**Consultation Response from KC,
Highways Development Management****2024/91566 Unit 4a, Holme Mills, West Slaithwaite Road, Slaithwaite, Huddersfield, HD7 6LS****Erection of extension to create new unit****Date Responded: 08/08/2024.****Responding Officer: D. Stainsby****Responding Ref: K1-24/7**

This application is for an extension to create a new industrial unit at Holme Mills

Proposed site layout plan (1:200).

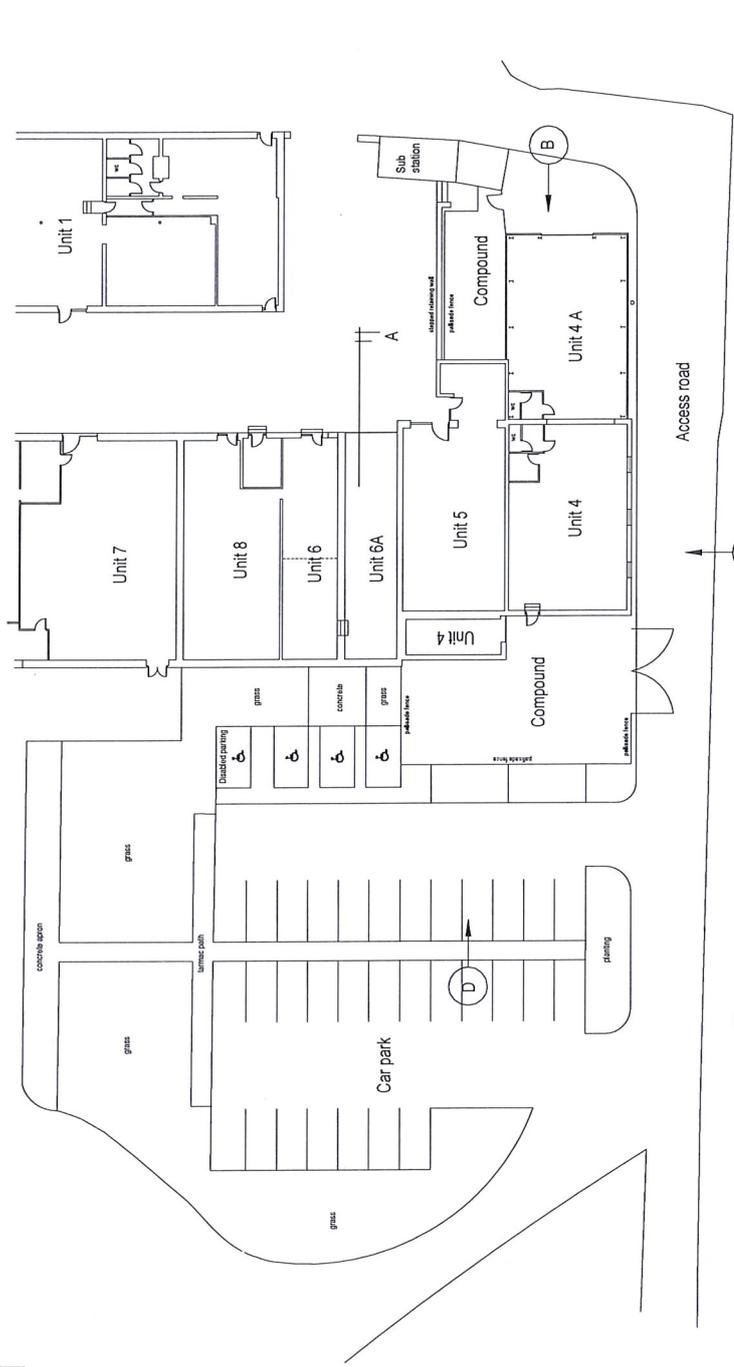
This compound will be replaced with the proposed new unit together with a smaller compound area, thereby displacing the current parking and service areas of the existing compound.

Unit 4 has a compound to the rear of its property with an access on to the adjacent access road and I am concerned that this will lead to loading/unloading taking place on this access road.

The proposed unit will have an access onto the access road adjacent to a right-hand bend. Again, without further information being provided, I have concerns that parking for loading/unloading will take place from the access road on the bend where visibility is poor for the users of the road.

It was also noted that the proposed unit would reduce forward visibility around this right-hand bend for both vehicles and users of the PROW further reducing road safety at this location.

As a result, I would consider that the proposal is an overdevelopment the site leading to parking and loading/unloading taking place on the PROW/Access Road on the approach to and/or on the right-hand bend at this location to the detriment of road safety on the adjacent PROW/Access Road.
